Comment to planning proposal ref: PO/6/22/HH

9 June 2022

We reside at Slate Cottage, the property immediately adjacent (north west) of the proposal site, St John's Cottage.

With regard to the revised planning application PO/6/22/HH, the latest proposal does not consider all the points of concern relative to the development of Historic assets and their Historic settings, as

Sheet Title
Proposed Floor Plans

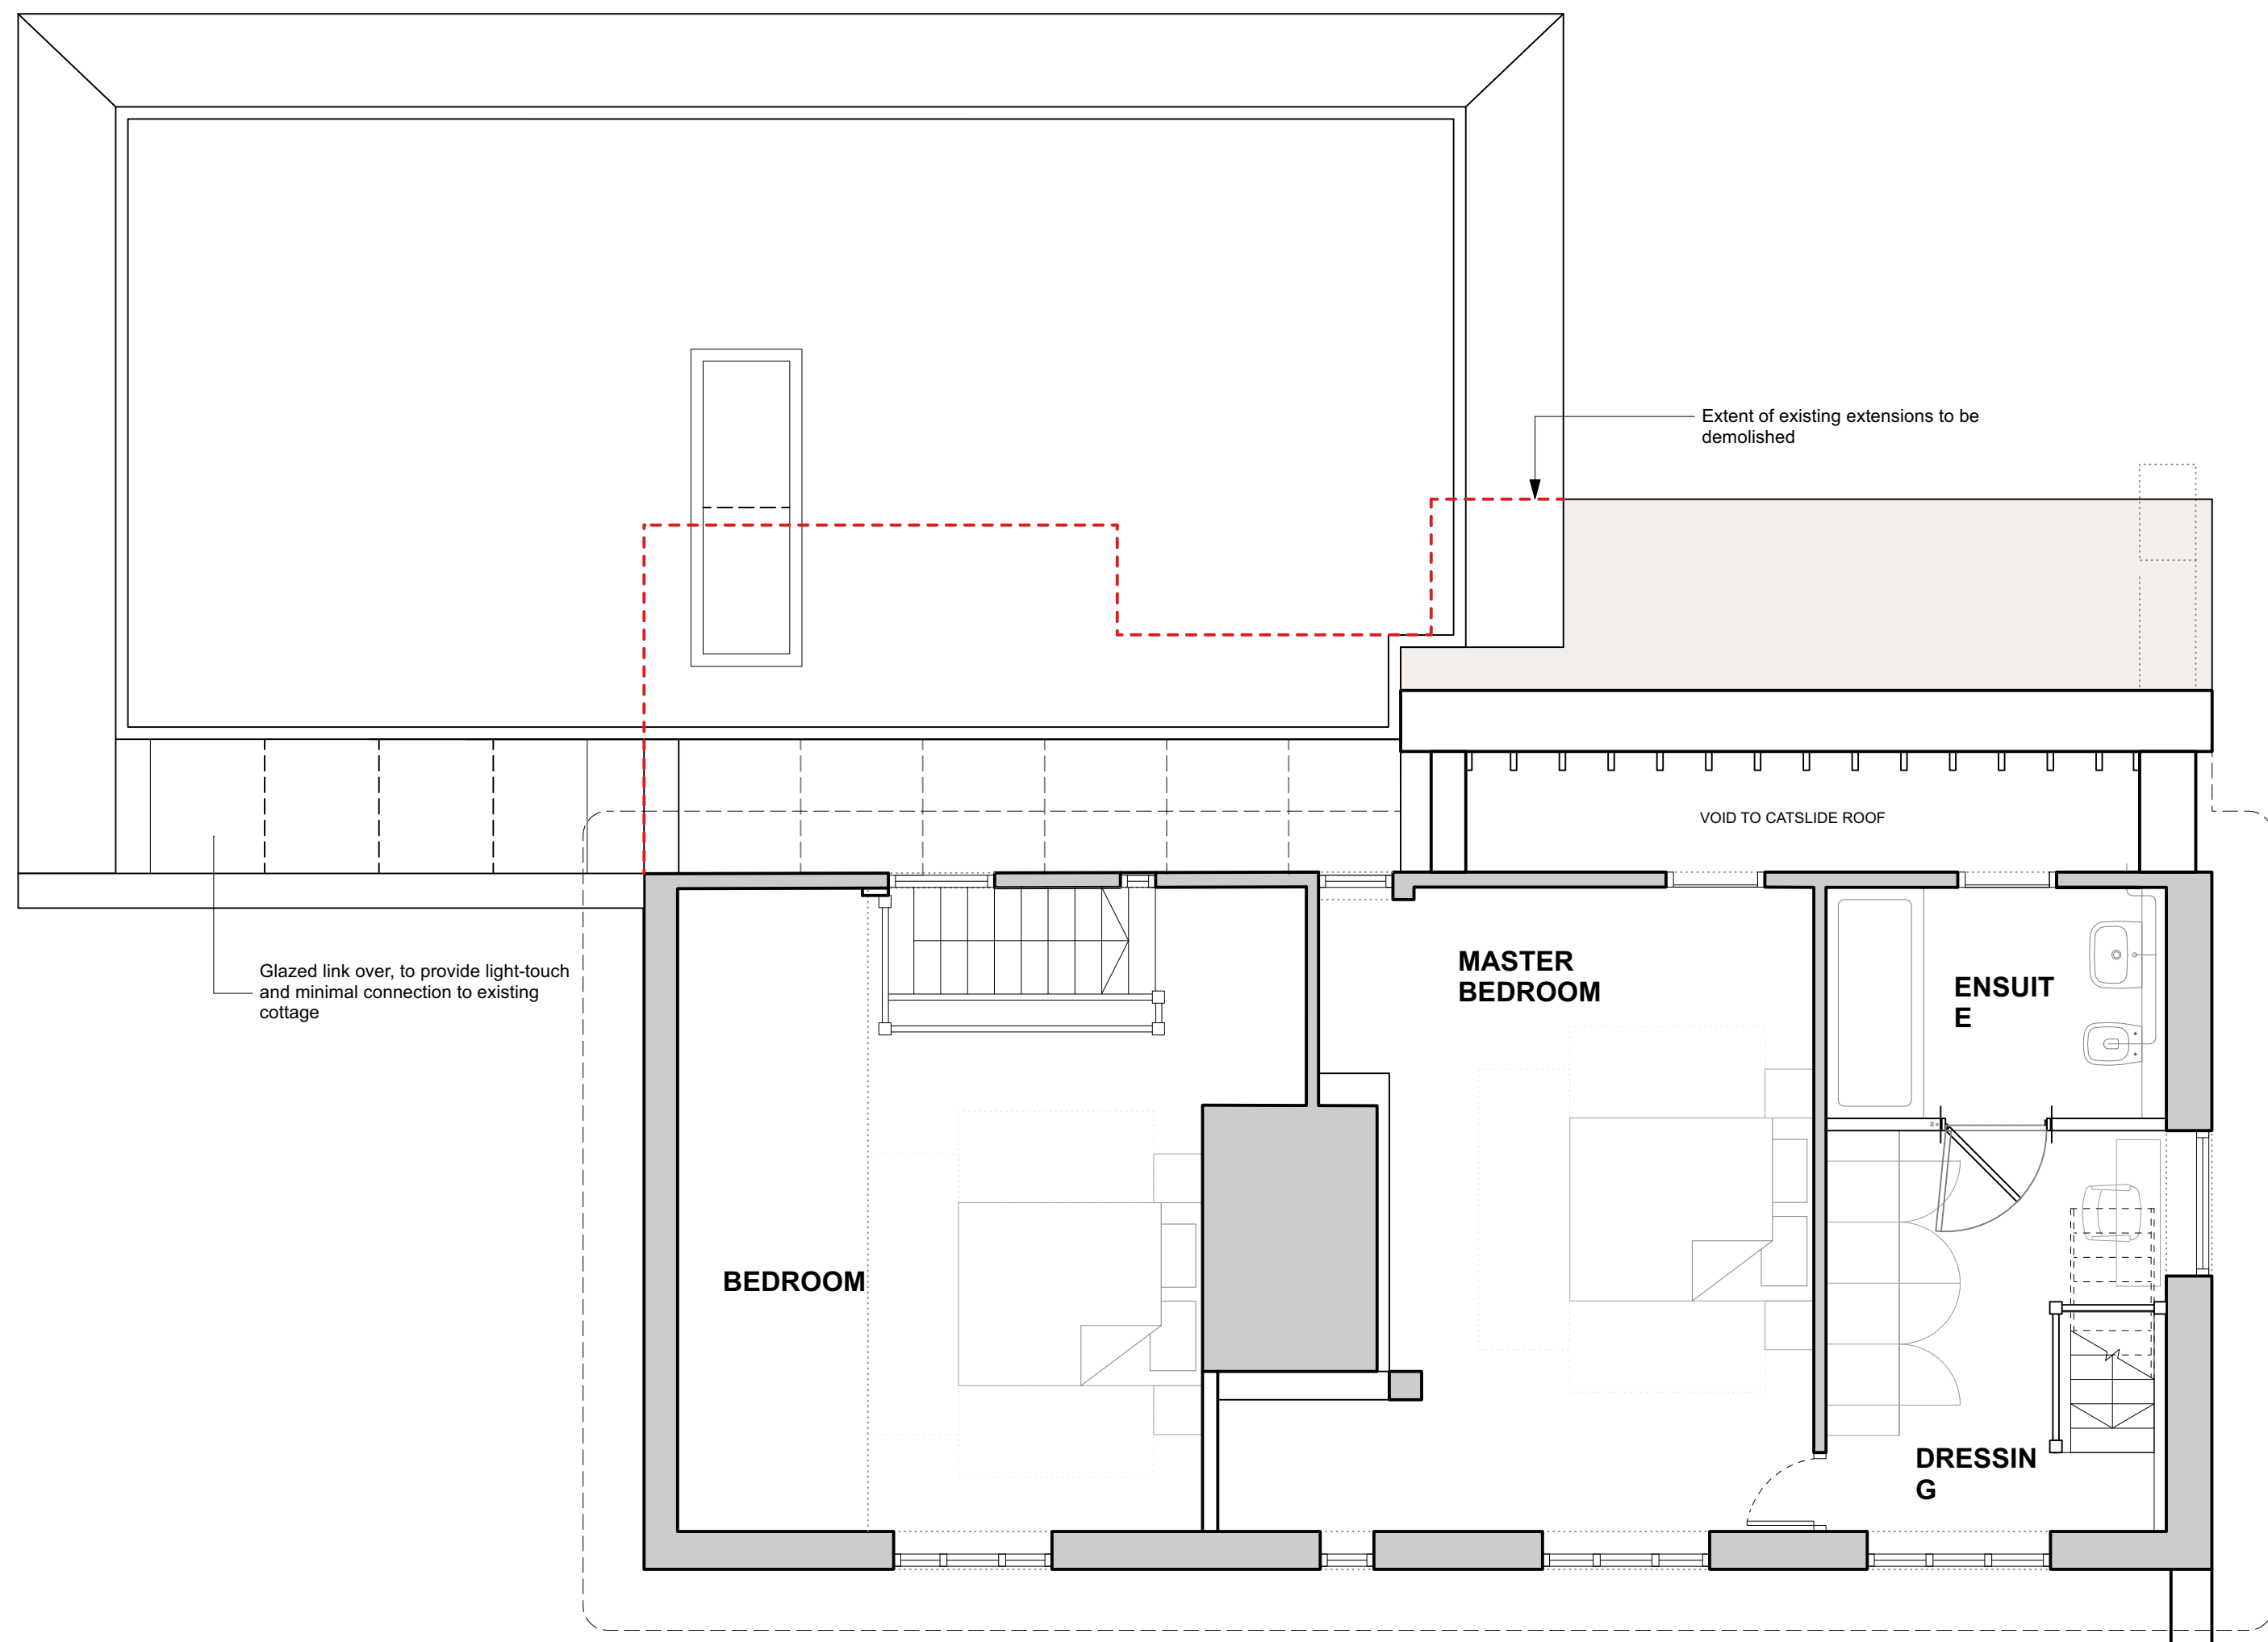
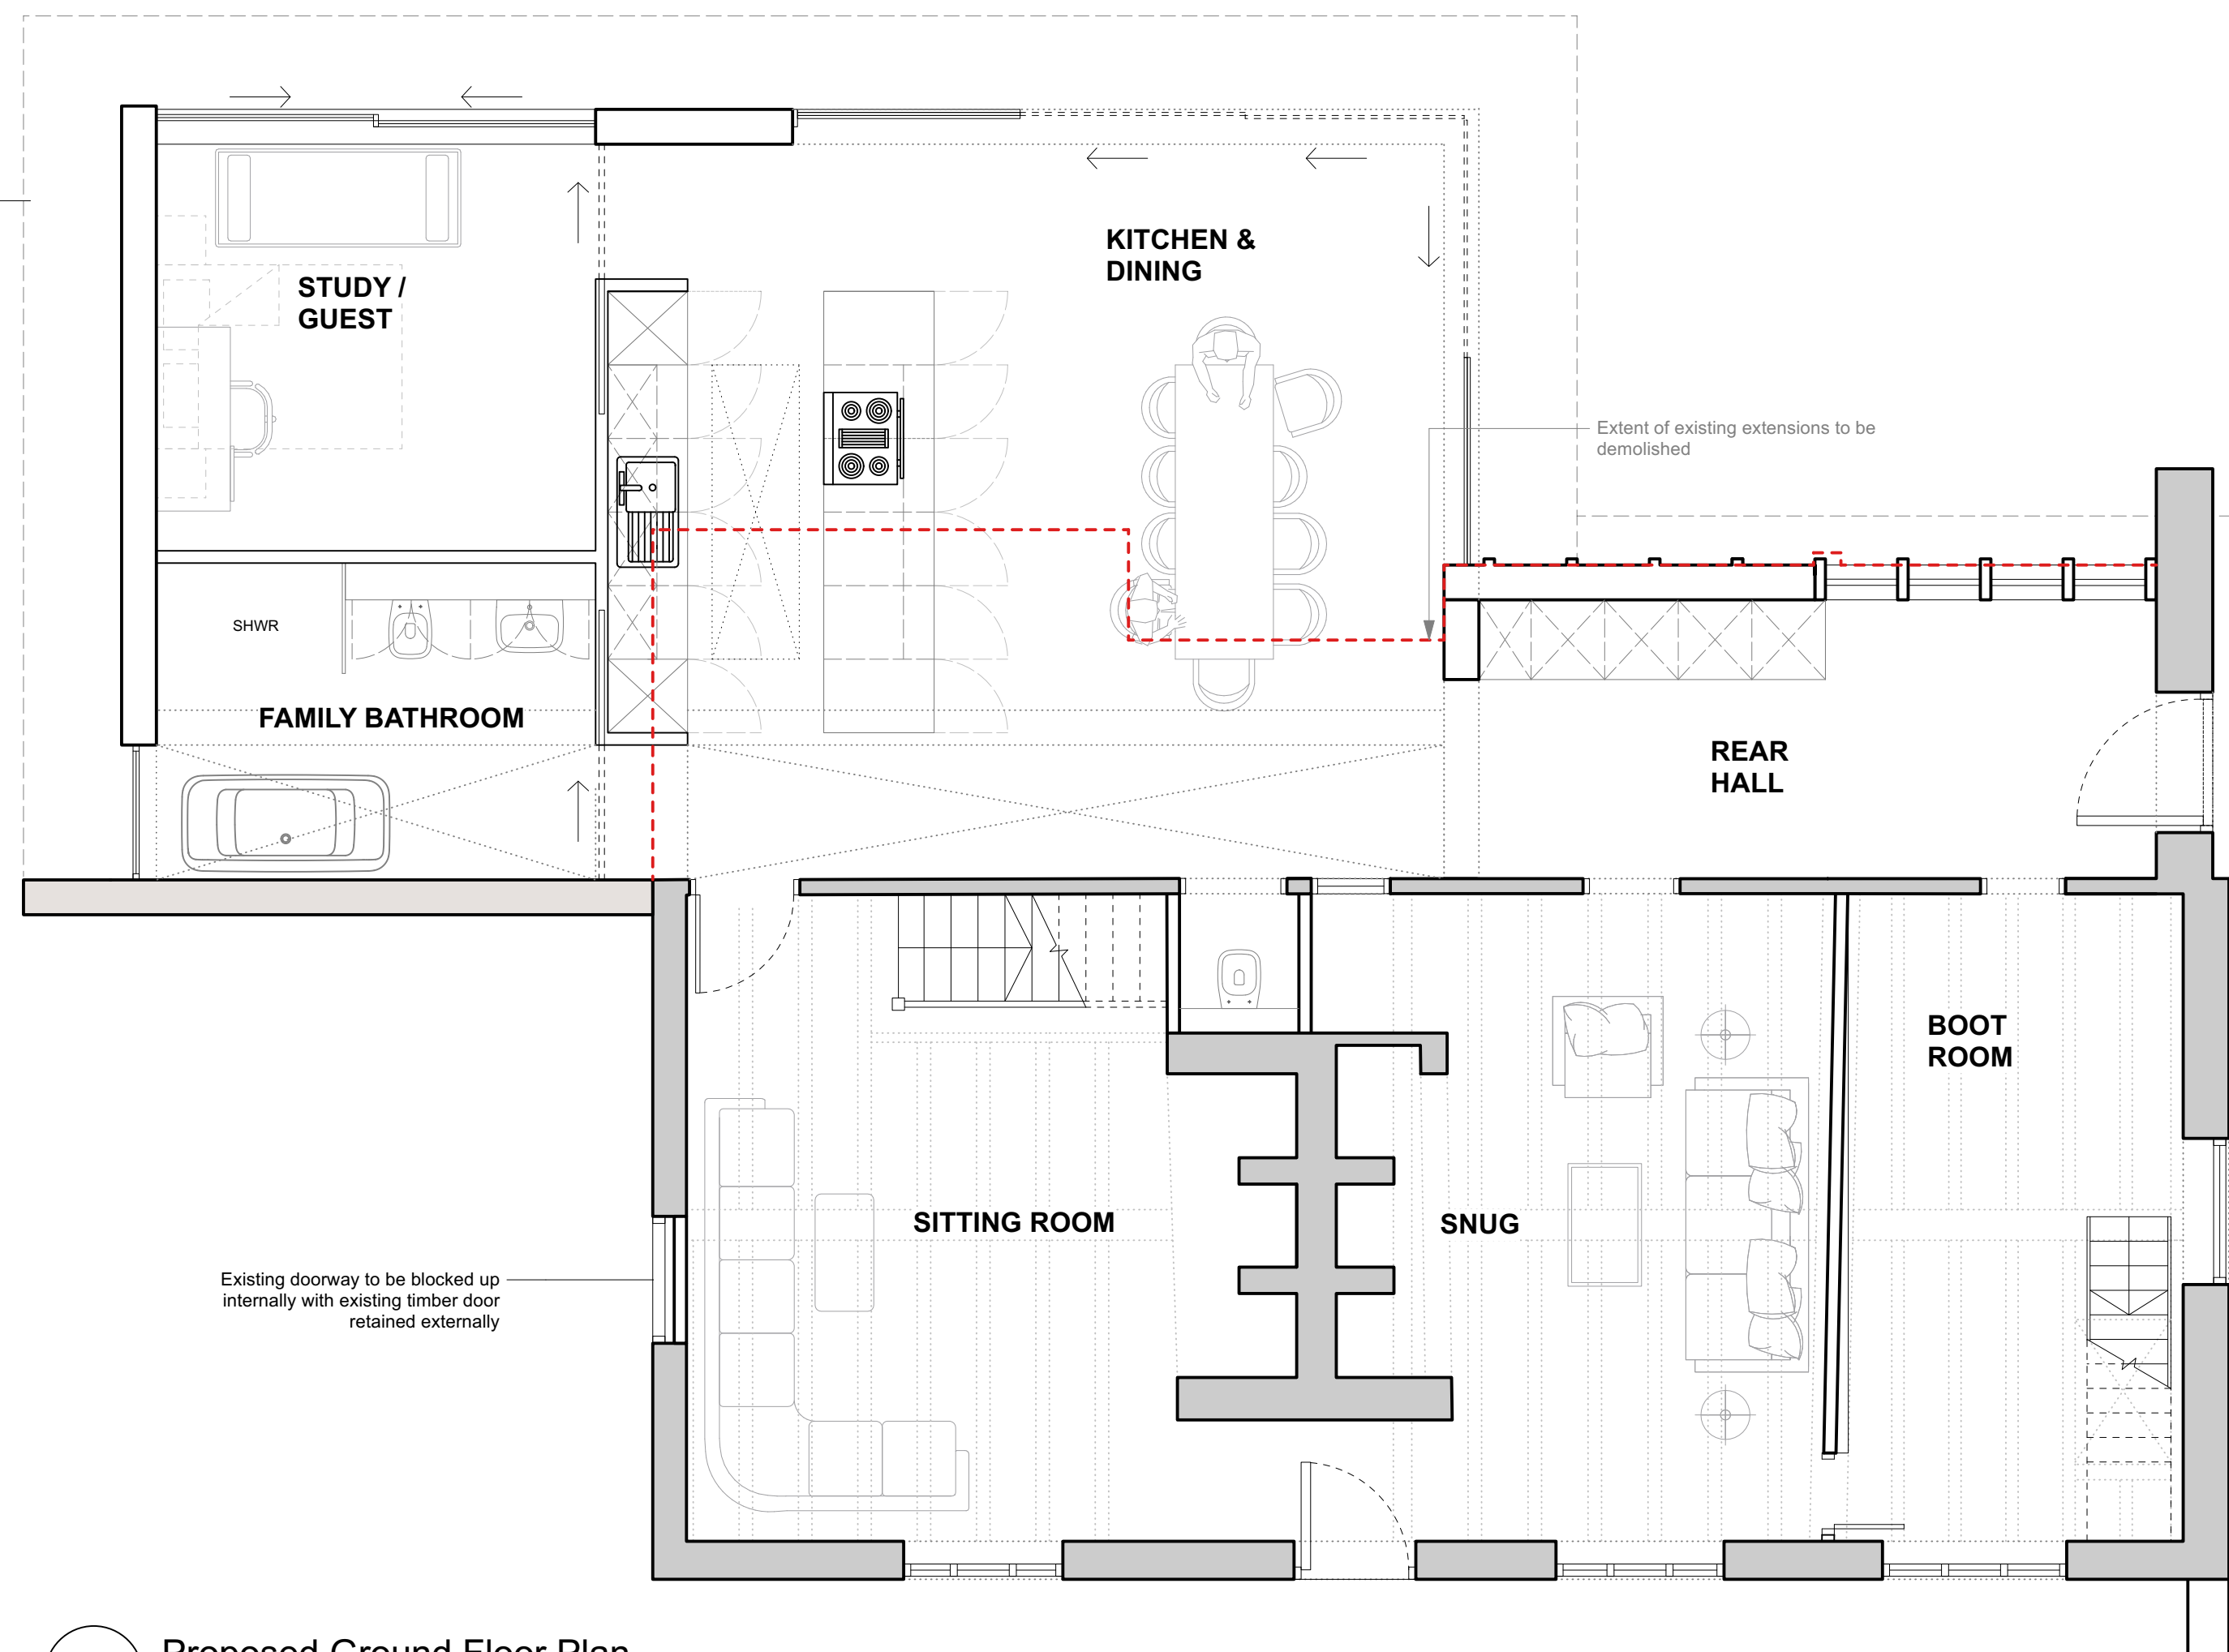
*'I am of the opinion that the extension would be substantial, with it appearing to occupy a footprint similar to the main listed cottage. Such an extension would not be subservient and considered to be out of character and harmful. Further, the extension would also be visible from the front elevation of the cottage, and that proposed elevation does not sit comfortably with the listed building.'*

St John's Cottage needs restoration and we would support any renovation work and development sympathetic and protective of its historical asset status and its special heritage setting. However, the new proposal still seeks to enlarge this historical site with an overbearing extension and garage. From the block plan, the extension alone seems to take up a footprint that would be similar to a detached dwelling in its own right and is little changed in mass and scale from that of the withdrawn proposal and therefore cannot be described as subservient to the Historical host dwelling.
